STIP No. A-0009CB

Concurrence Point 4B, Hydraulic Design Review Meeting Minutes

Purpose: The purpose of the meeting was to review and discuss the 30% drainage plans for STIP A-0009CB. The limits of the A-0009 CB Section are NC 143 from SR 1223 (Beech Creek Road) to 0.5 miles north of the Appalachian Trail.

3/30/2021 X:\NC009\A-0009\Hydraulics\MERGER\A-0009_CB\CP_4B\Plan_Sheets\A-0009CB_Rdy_psh_28.dgn 8/17/99

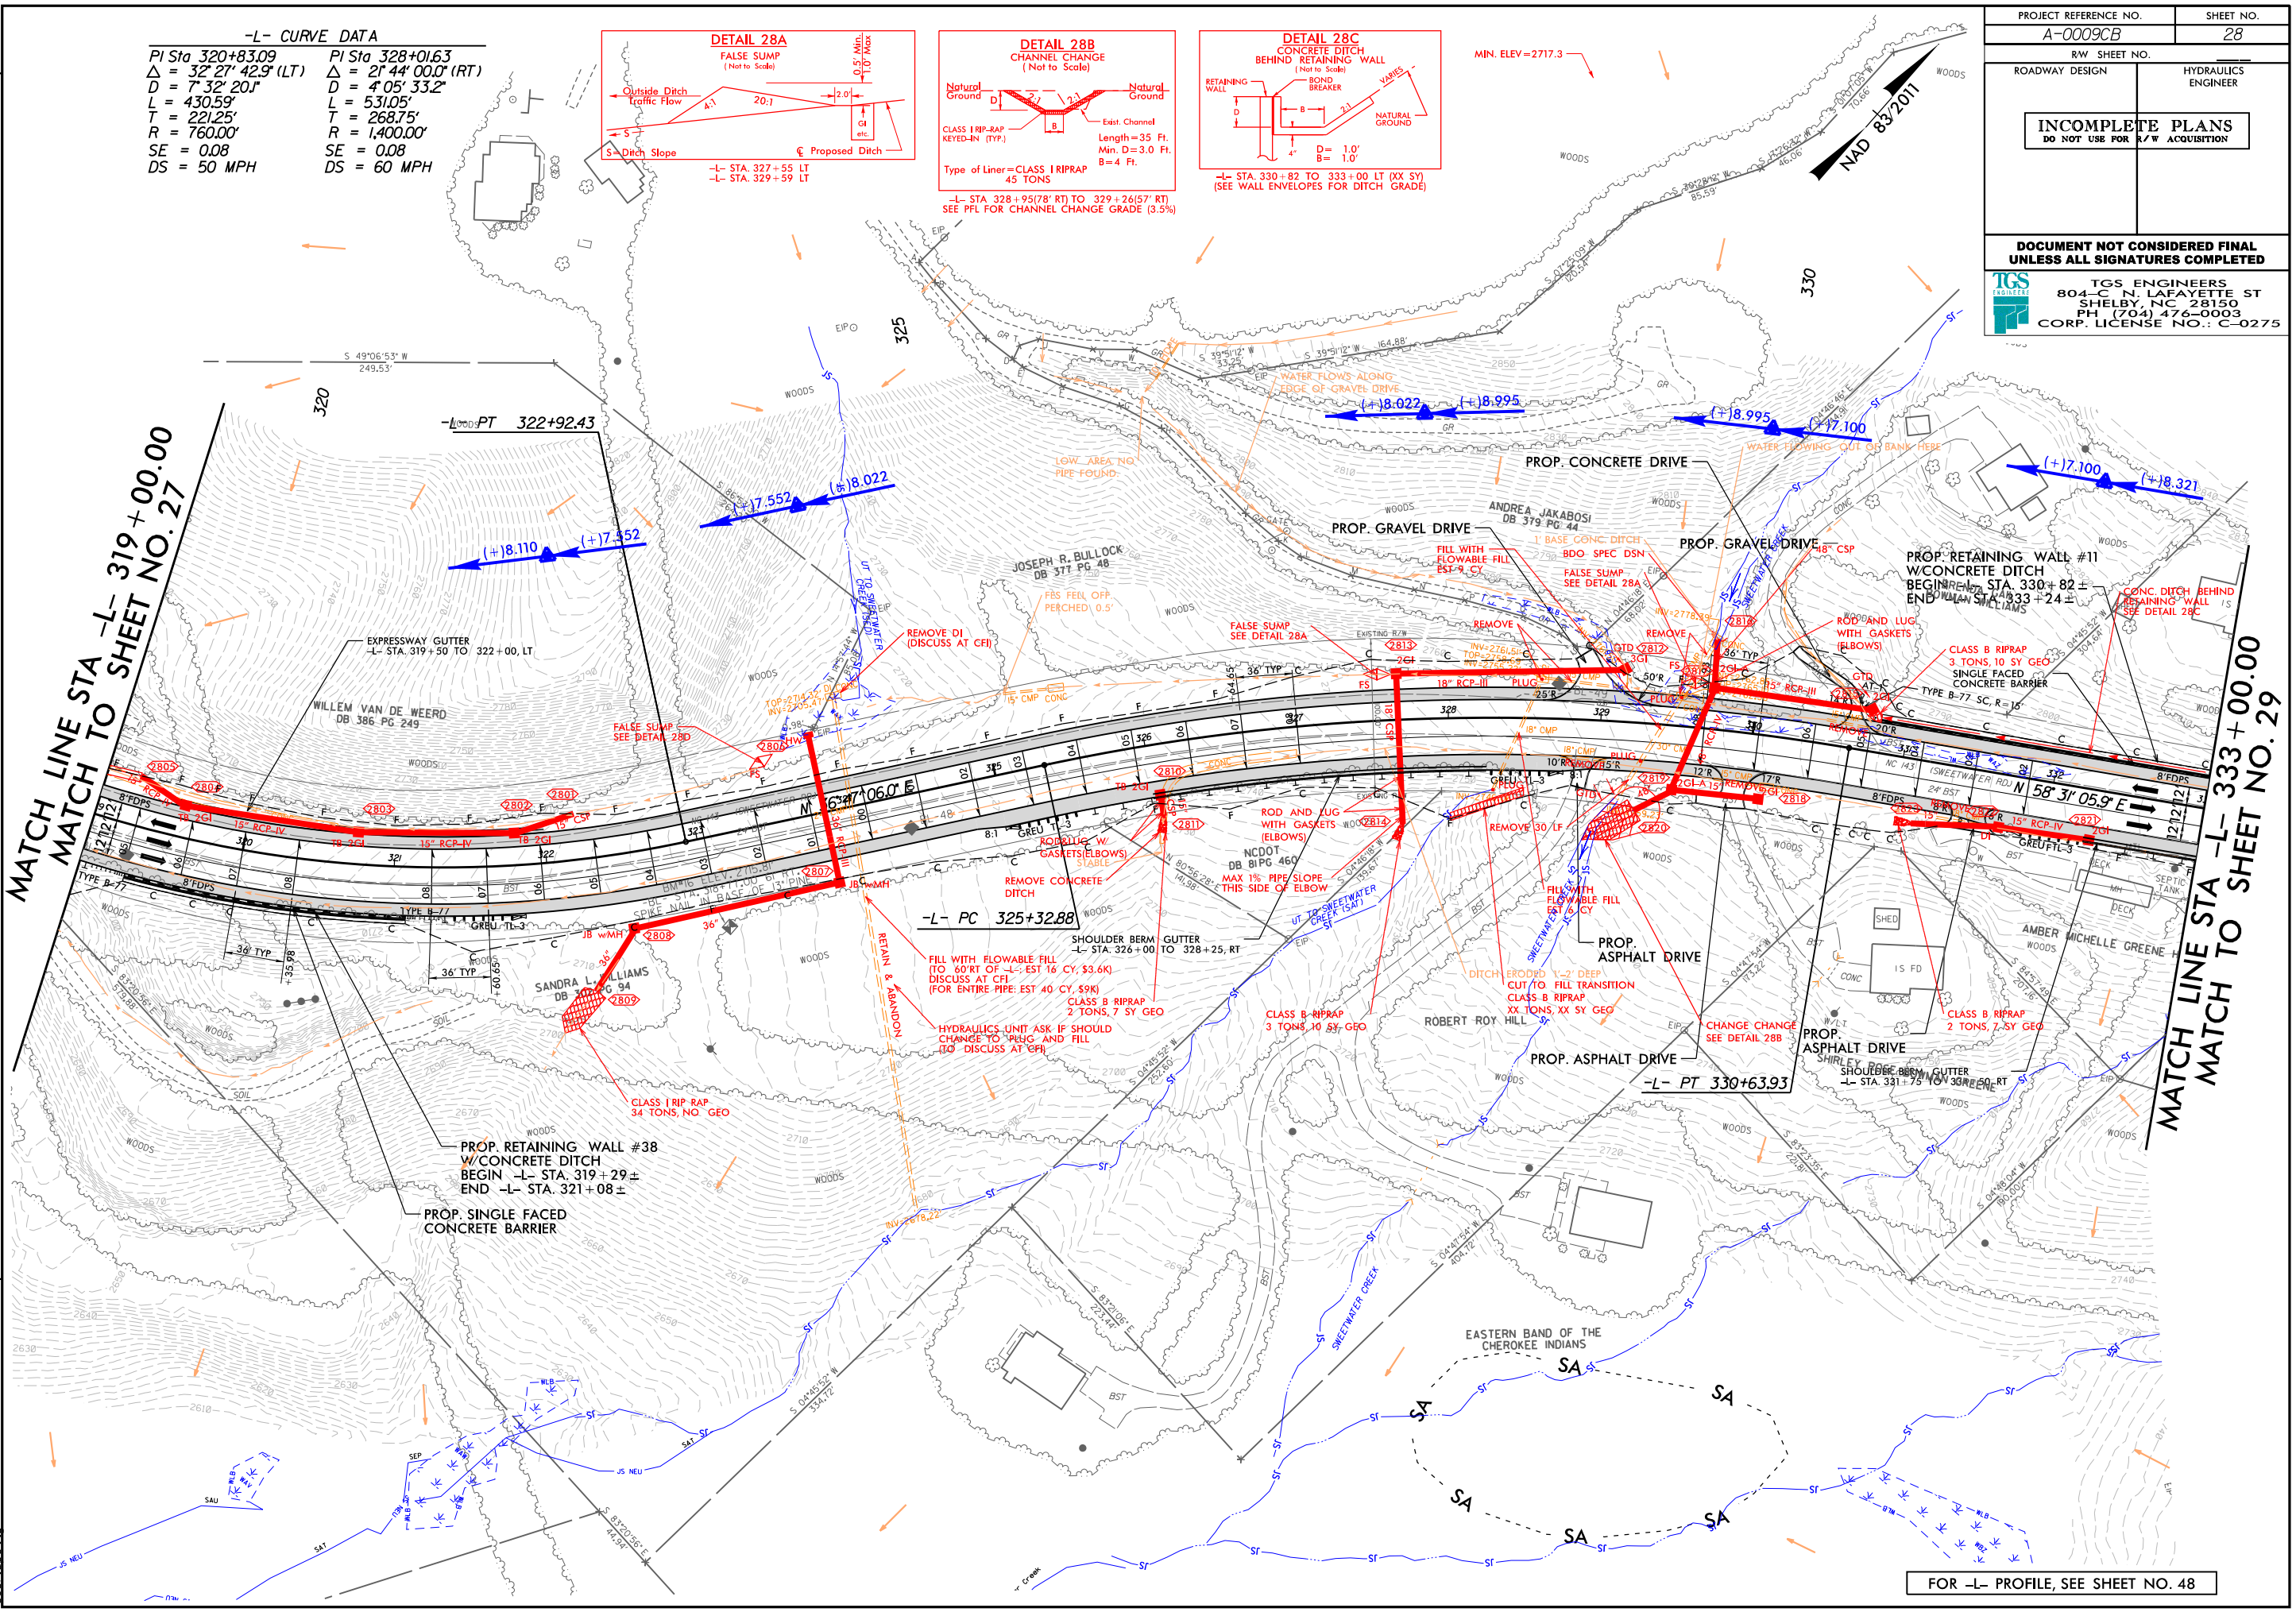
- Stream is only jurisdictional on downstream side
 - TGS noted that the outlet will be shifted 20-feet upstream to outlet in jurisdictional stream per updated surveys. A detail will be prepared per NCDWR request earlier.
- Sweetwater Creek (WS-III, Tr), perennial, on -L- at Station 329+50

- USACE questioned why the system is not being replaced in a straight line because it looks as three pipes with junction boxes. Further explaining that the system could go straight across NC 143 instead of off-line because it is not ideal to create a longer system. USACE stated that justification is required for the longer system.

- TGS responded that the system is not in a straight line due to constructability reasons.
- USACE stated additional information is needed to explain why the existing alignment can be maintained. USACE further stated that Sweetwater Creek is a big stream, and it would be ideal to keep it on a straight line.

- USACE stated that the slope is a concern at 51%. More information is required to understand the constructability concerns/issues for this crossing. USACE believes that a shorter, straighter system with minimal slope would be ideal, if possible.

The existing 24-inch CMP on an average 8% slope will be replaced with a 36-inch system to minimize the slopes and velocities and remove the 9-foot drop.
- The proposed system layout restores the pre-1950's drainage pattern (per 1941 USGS quad) and minimizes jurisdictional impacts. The section of NC 143 was realigned to the current alignment in the 1950's.
 - NCDWR voiced concern regarding the erosive velocity going down the new outlet valley.
 - TGS responded that they were still coordinating with the NCDOT Hydraulic Unit and Division 14 Construction on Stream "SED". TGS further stated that in the 1950's the proposed location is where the jurisdictional stream went and felt confident the area was stable.
 - NCDWR asked if the dissipator pad was for a 10-year design.

- TGS stated that the flow must be maintain because it perennial. TGS agreed to look further into this crossing as there is nothing easy that could be done to construct.

- TGS responded in the affirmative and will show V10 on the 4C plans.

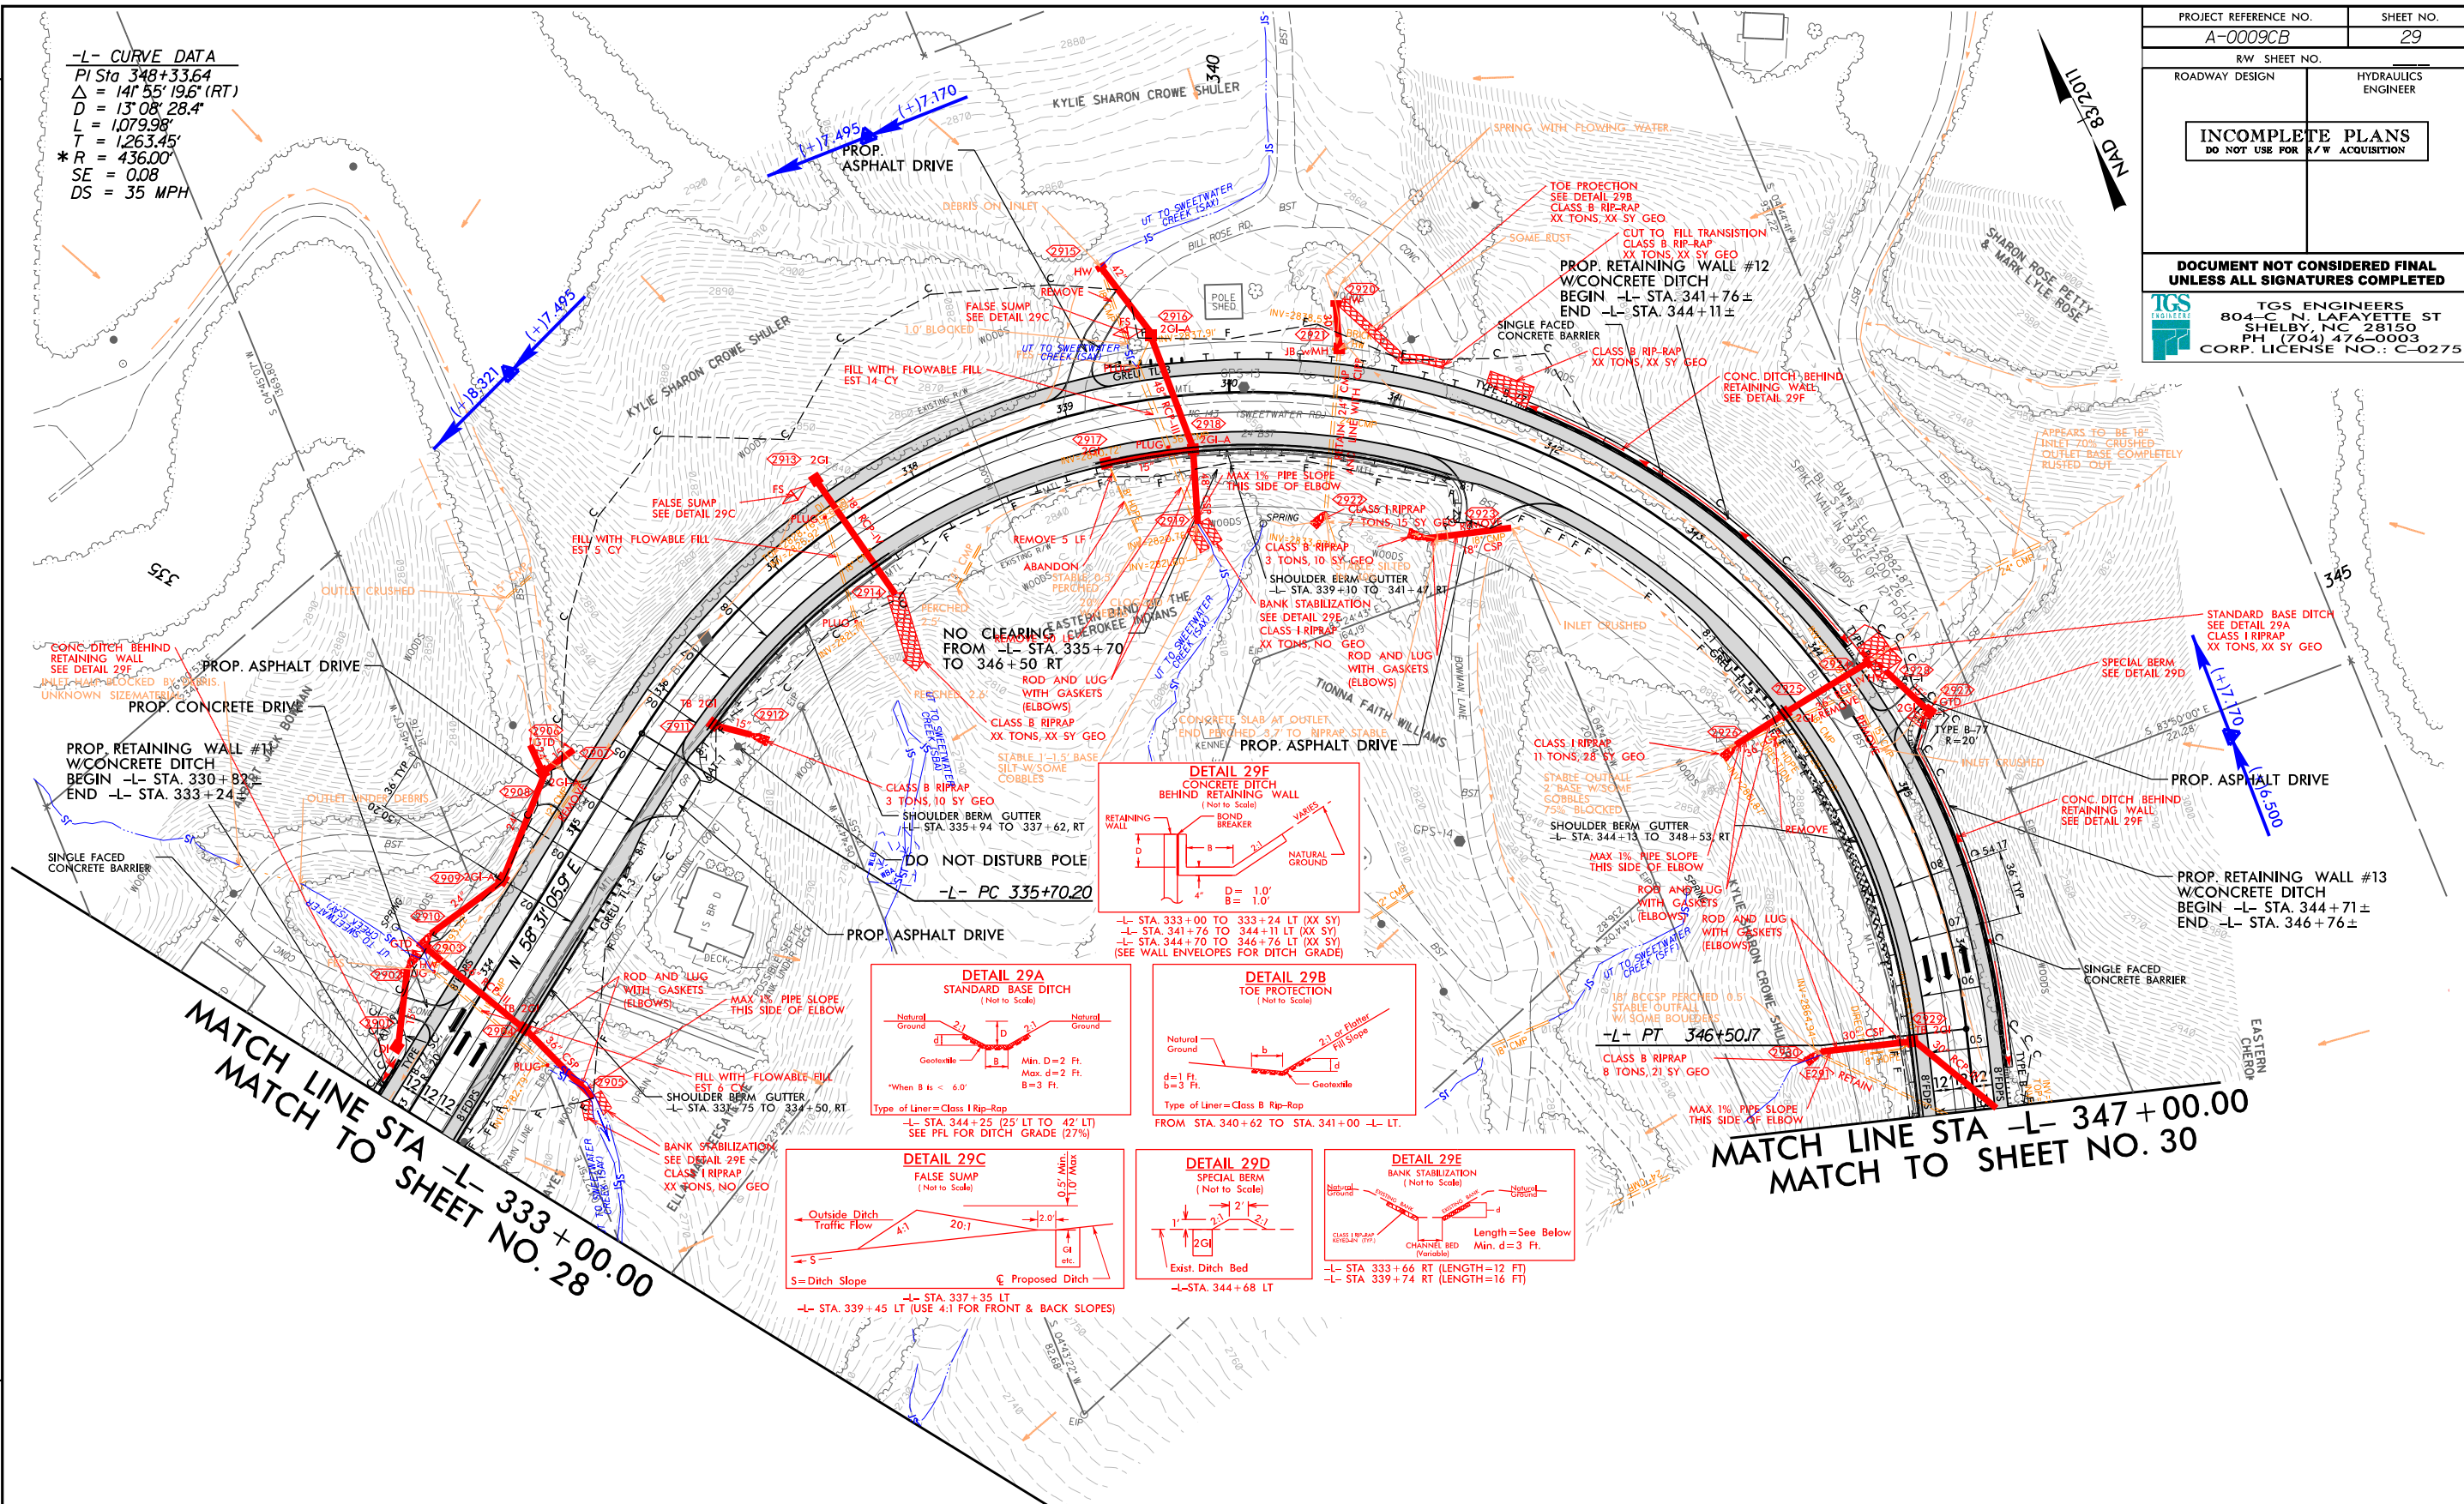
- USACE inquired about the burial of the new pipes.
 - TGS responded that the slope was too steep to bury.
 - USACE requested that a note be added to the plans stating "DO NOT BURY INVERT"

- TGS agreed to add a note here and at similar locations.
 - USACE stated that entrance at 2915 is going in at a 90-degree angle which is sharp and could be an issue

- TGS responded that Rip-Rap will be added at inlet to avoid erosion.
 - Division 14 reminded the Team that Tribal land is present in this area. USACE suggested that Division 14 reach out to Gary Snead to discuss permitting on Tribal lands.
